City of Albuquerque Stormwater Construction Site Inspection Report

ESC File No.	H15E068	Project Name:	Maverik		
NPDES Id. No.		Location:	1901 Menaul blvd NE		
11/4/2020	Property Owner		Contractor		
Operator	Maverik, Inc.				
Contact name & title	Troy Jorgensen				
e-mail	troy.jorgensen@maverik.com				
Contact Phone #	801-335-3851				
COA Inspector	Doug Hughes		Start/End Time:	2pm	
Construction Phase:	Earthwork				
Type of Inspection:	<input type="checkbox"/> Regular	<input type="checkbox"/> Storm Event	<input type="checkbox"/> Post Storm Event >0.25"	<input type="checkbox"/> 311/Complaint	<input type="checkbox"/> Follow Up
Weather at time of inspection?	Clear		Temperature: ~	76	
Estimated date of last storm 0.25" or greater

ENGINEER'S SEAL	MAVERIK UNIVERSITY AND MENAUL	DRAWN BY VP
		SWPPP LAYOUT AND ESC PLAN 1	DATE 1/6/2020
		TERRA WEST, LLC 5571 MIDWAY PARK PLACE NE ALBUQUERQUE, NM 87109 (505) 858-3100 www.tierrawestllc.com	2018062-SWPPP
			SHEET # SW1 JOB # 2018062

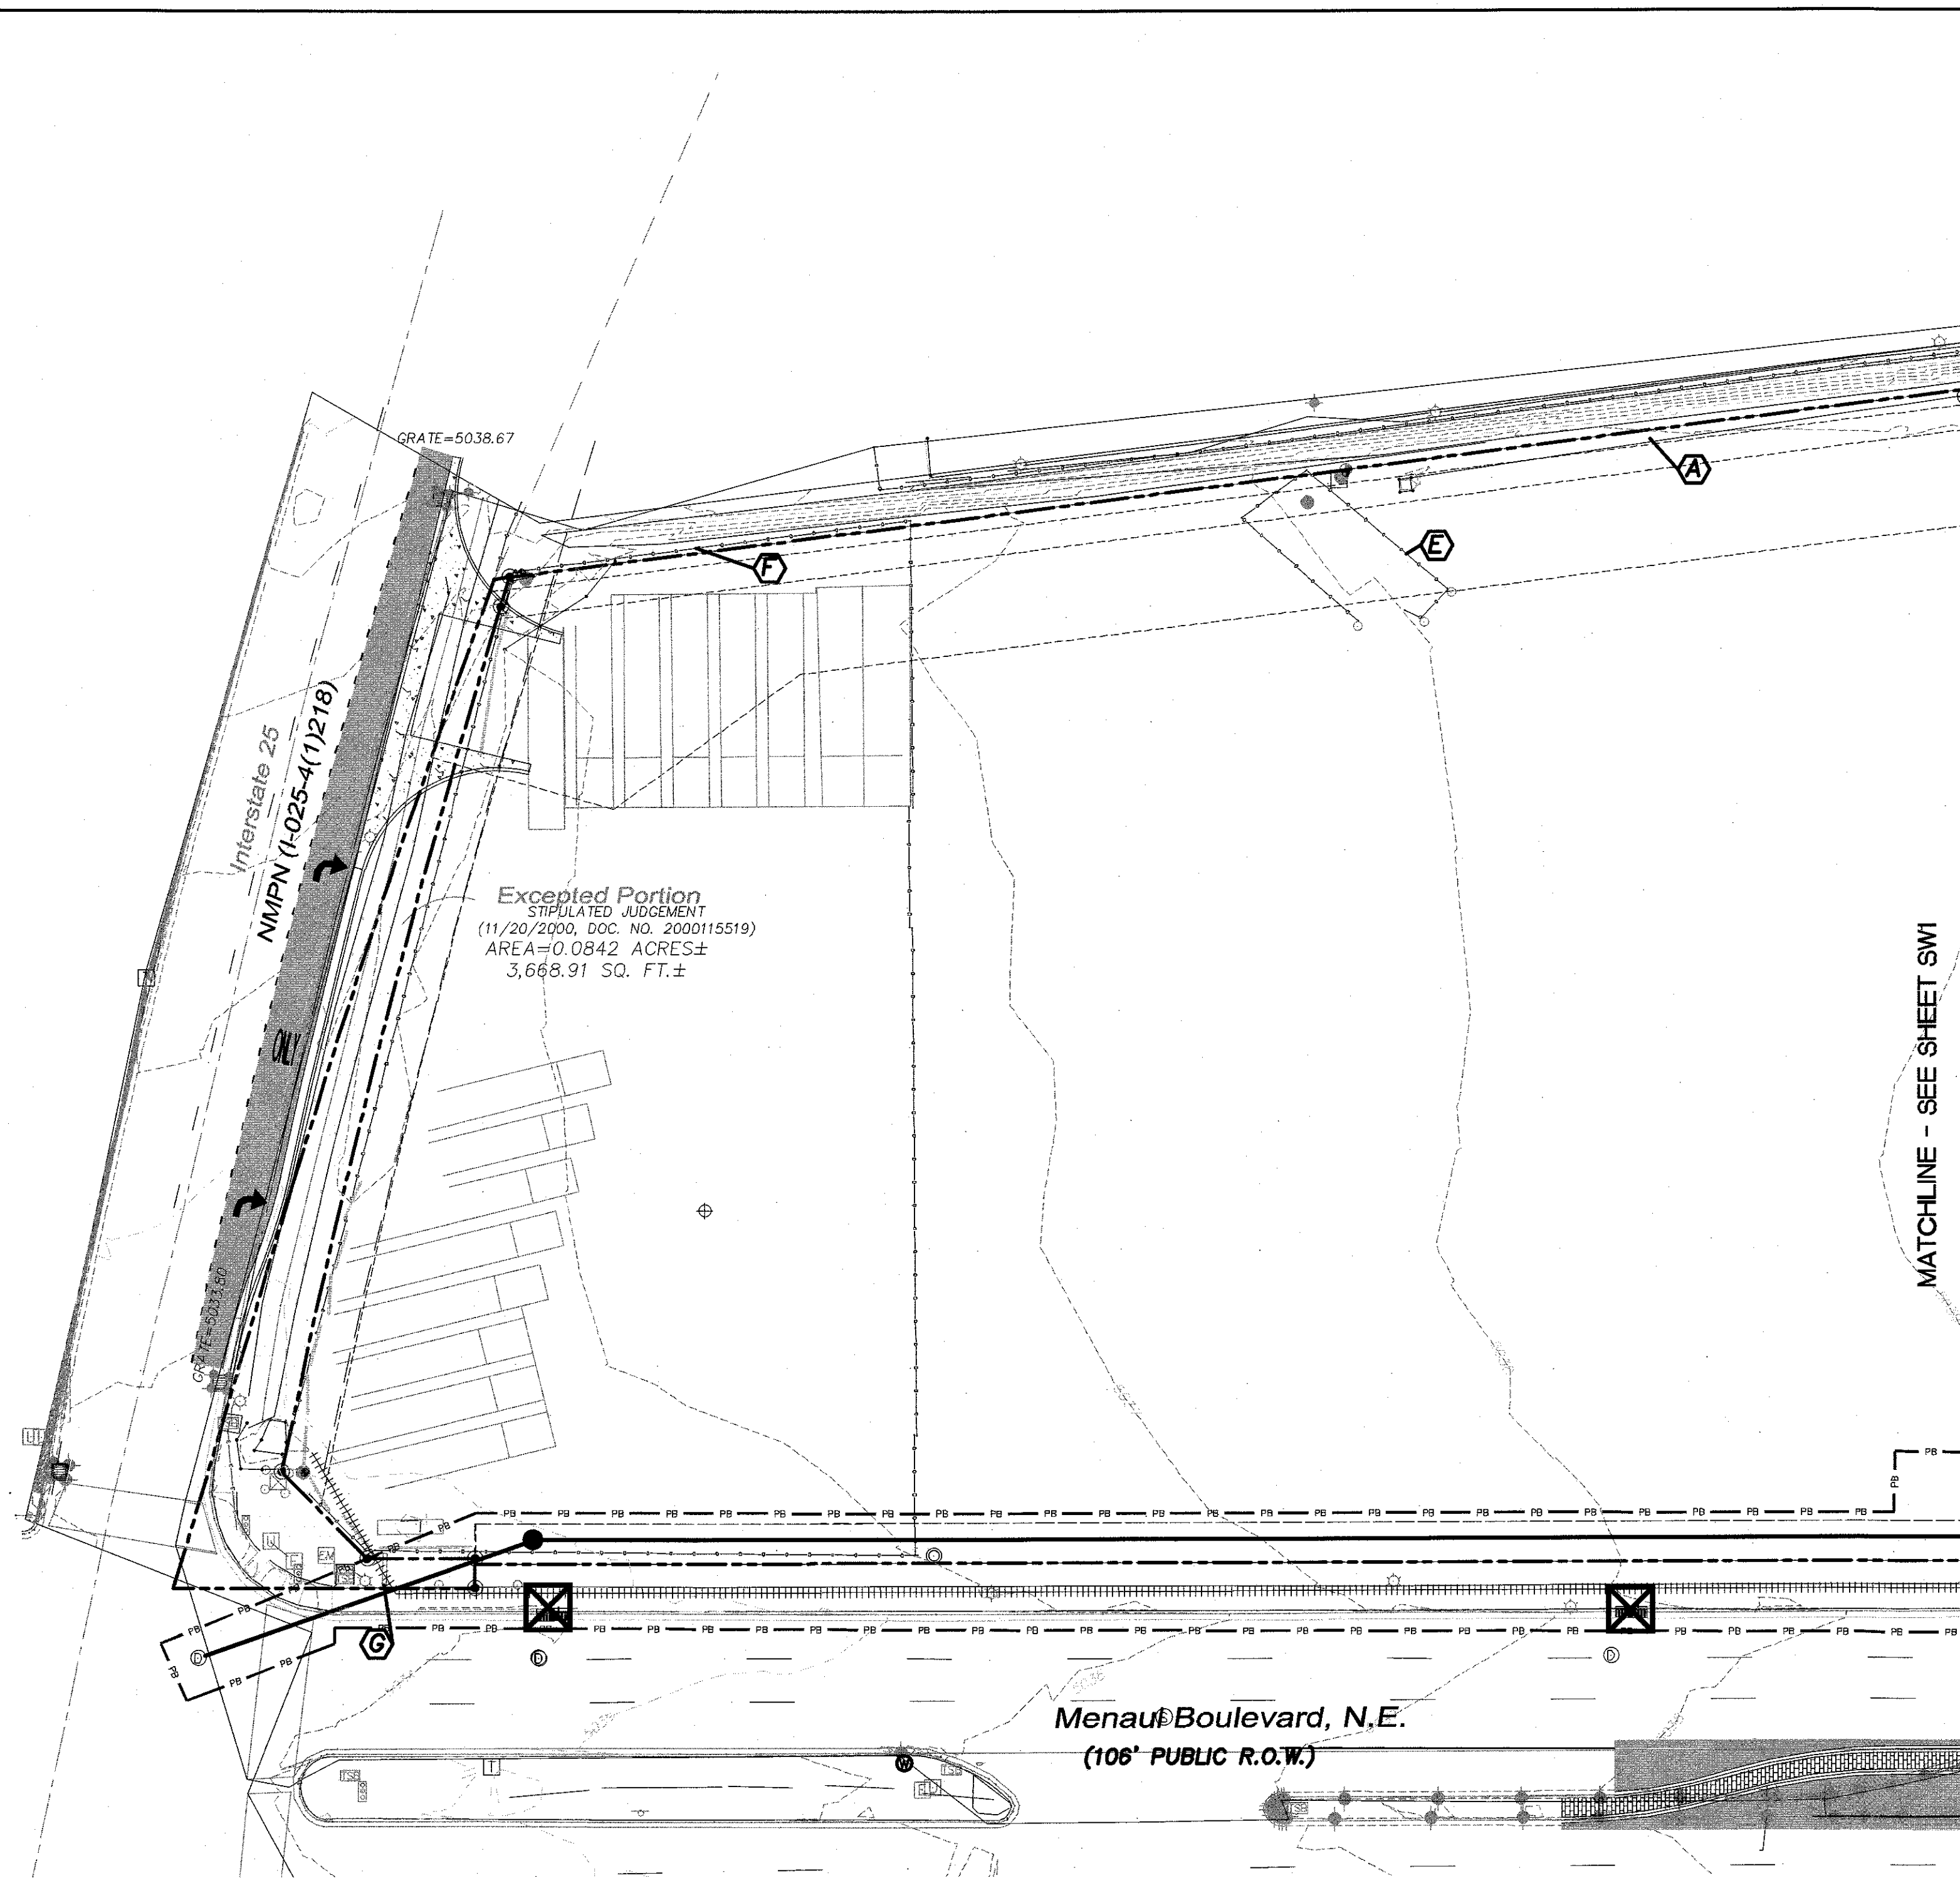
Item Number	Deficiency/ Corrective Action				
1	Silt fence not embedded and big gap (inpromptu entrance) at low point. Abandon the entrance in low corner and never have another hole in the silt fence again so long as this project lasts. Silt fence embedment is 12" minimum and faberik is 4' high per detail on approved plan.				
2	Construction debris not in acceptable container				
3	Inlet protection (sandbags around perimeter) three inlets in menaul in low corner.				
4	The ponds in the low corner are missing. See approved plan. It is supposed to be the first item of earthwork construction.				
5	Sediment in Menaul at inpromptu entrance and at c&g Construction must be removed daily.				
6	Where is the SWPPP?				
7	Provide SI contact info.
